Planning Application Ref: 23/01200/HOU
RE: 26 Seaforth Gardens, London.N21 3BS

Ref: Two storey side extension, single storey rear extension and loft conversion with two rear dormer windows and rooflights.

Further to the planning approval for the above application, my Client wishes to make some minor non-material amendments. These include the following amendments:

PROPOSED GROUND FLOOR PLAN

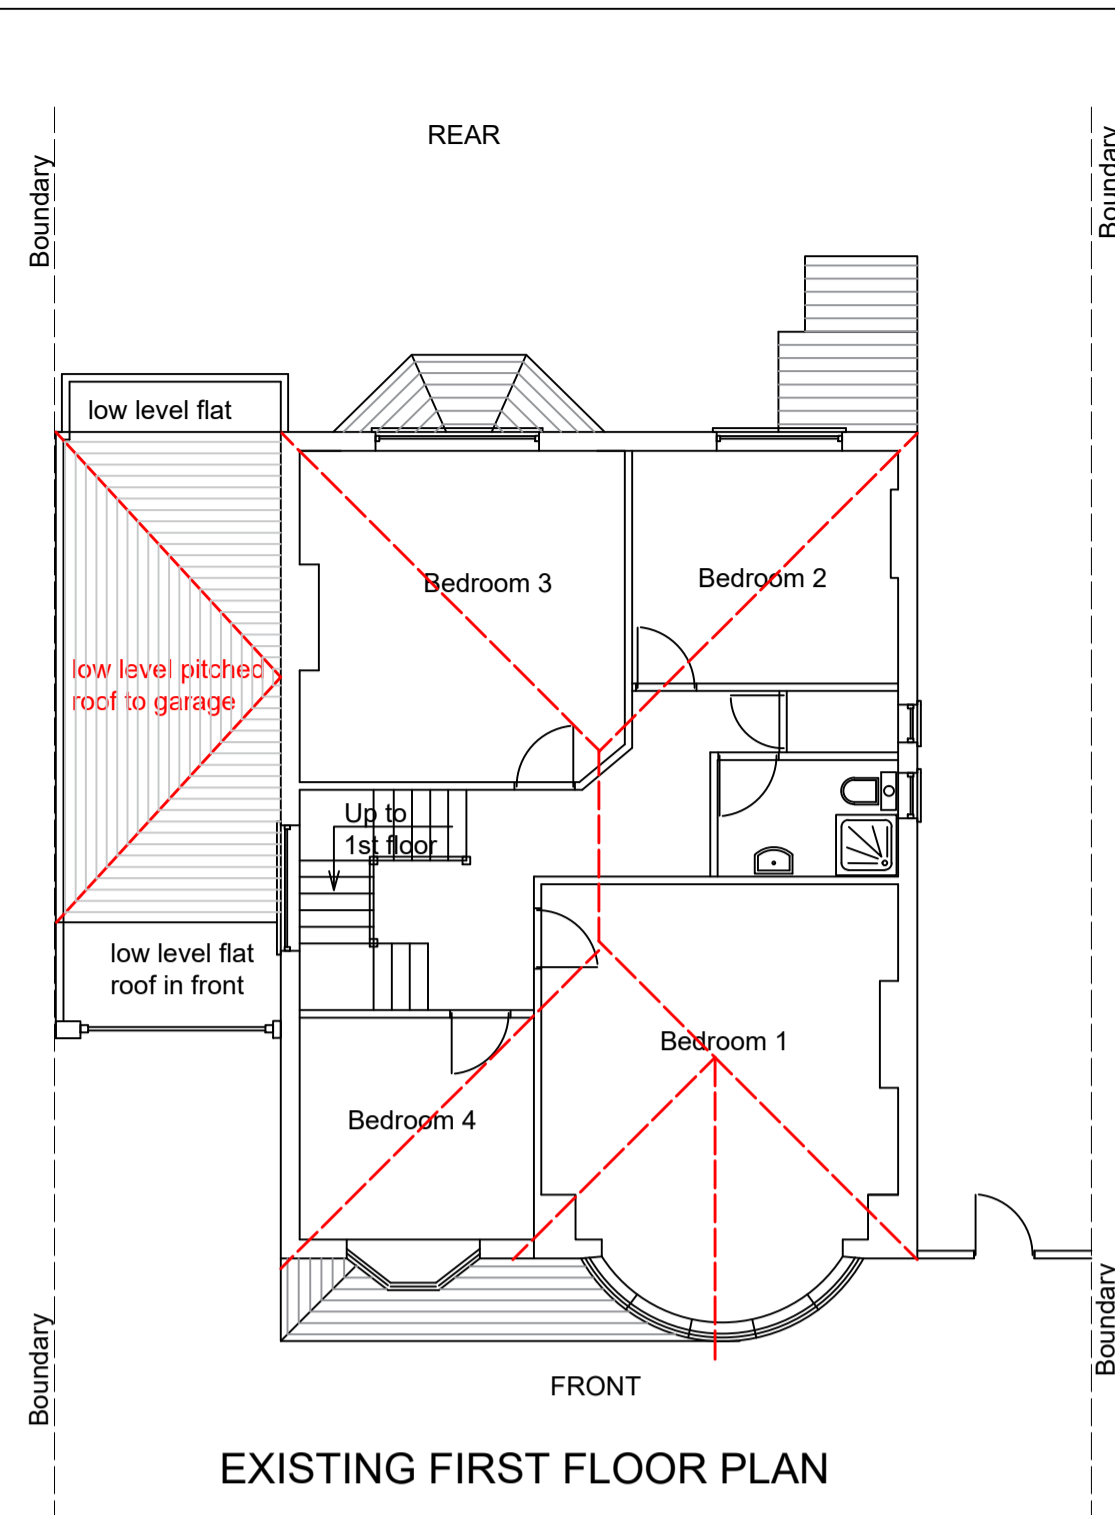
1. Increasing part of the single storey rear extension to a depth of 4.8m.
2. Altering the roof to the single storey rear extension to a part pitch roof and flat roof.
3. A wrap around pitch roof to the front, side and rear ground floor extensions.
4. Altering the roof dormer to a single larger dormer.
